From: Sue Howell
Sent: 21 May 2018 16:22
To: Planning.Responses
Cc: David Easton
Subject: RE: Planning Consultation on: F/5/18/RES

Comment from Greenspace

APPLICATION F/5/18/RES

Site Address: Land South of Burndell Road Yapton BN18 0HR

This drawing contains:
Topo = (February-14-2018) 13:4718
Layout = (February-22-2018) 1000 1.01 Rev P5

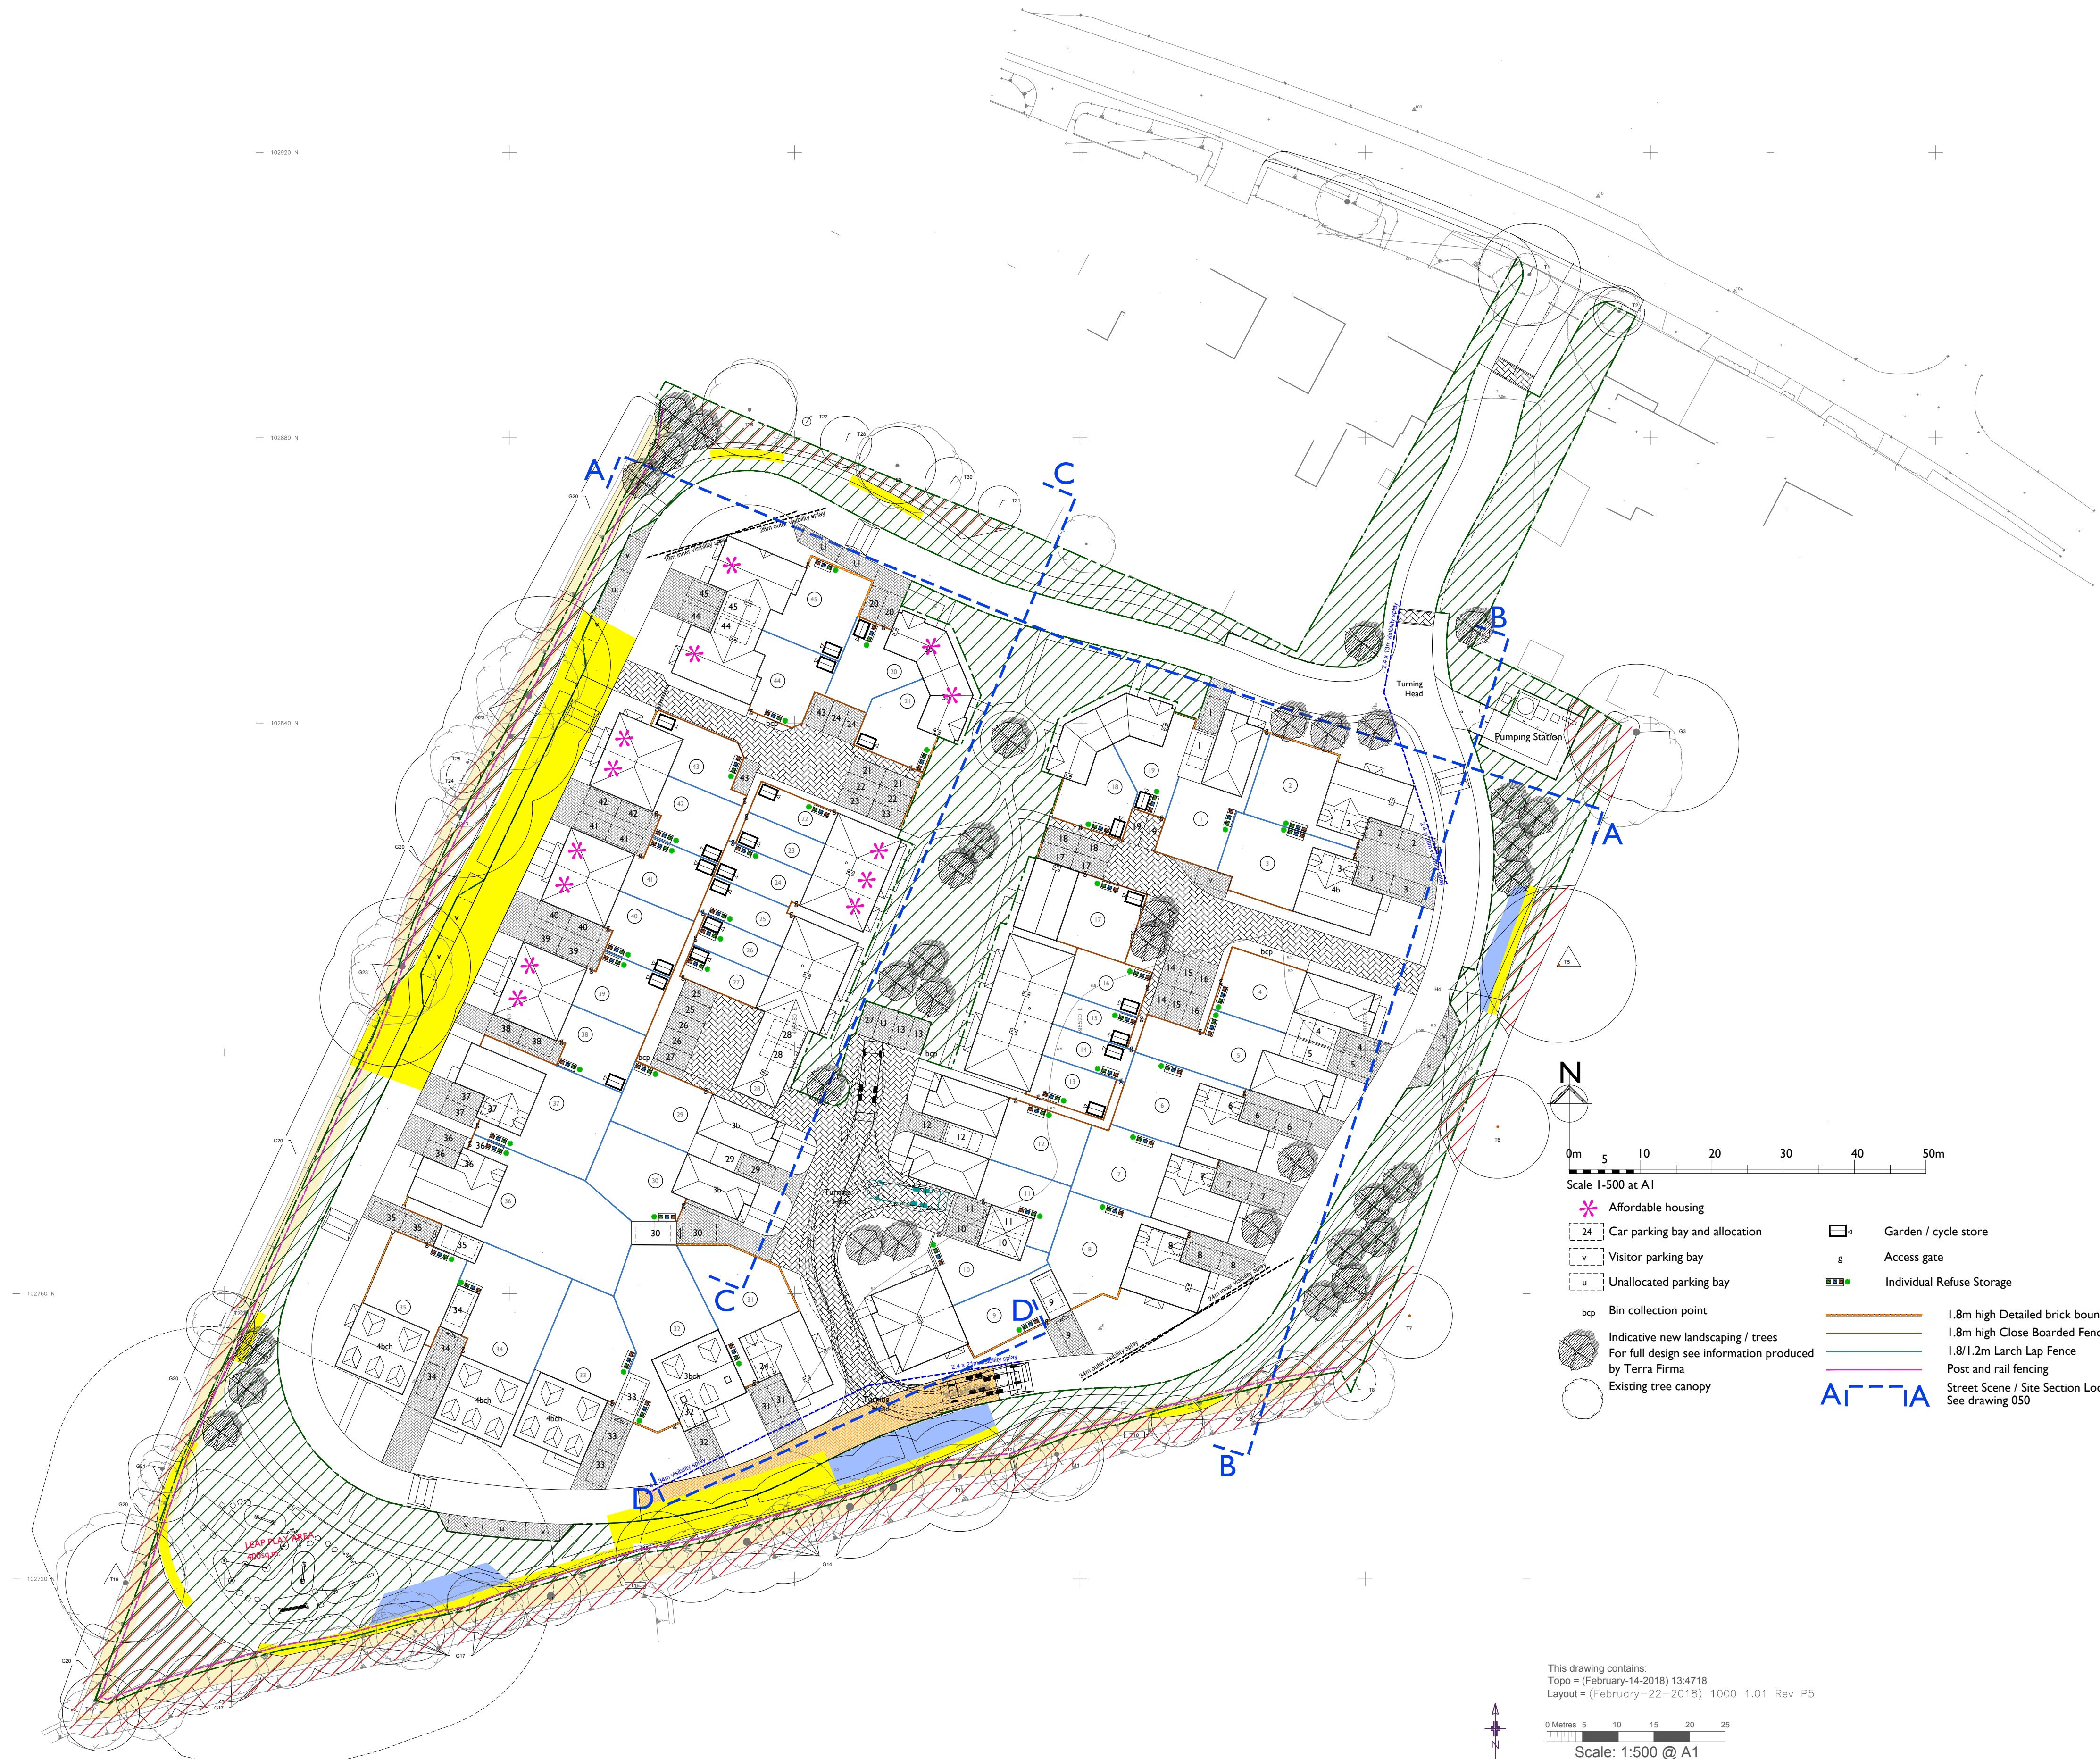
The revised site layout now allows for the onsite children's play to be located within the greenspace to the south of the site which was at one time earmarked for 'pond' it is assumed that this area is now not to be a pond and has in fact now been earmarked for POS and play. On this assumption it is perceived that drainage provision within the site has been accommodated in some other form and will not conflict regarding open water body in relation to POS areas.

1. The play area LEAP is detailed as provided by others, further detail regarding play offer proposed to be confirmed along with detail re fencing and connectivity to pathways to be provided.
2. Detail of management proposals for Open Space areas along with responsibilities for these areas on completion of development would be required to be confirmed.
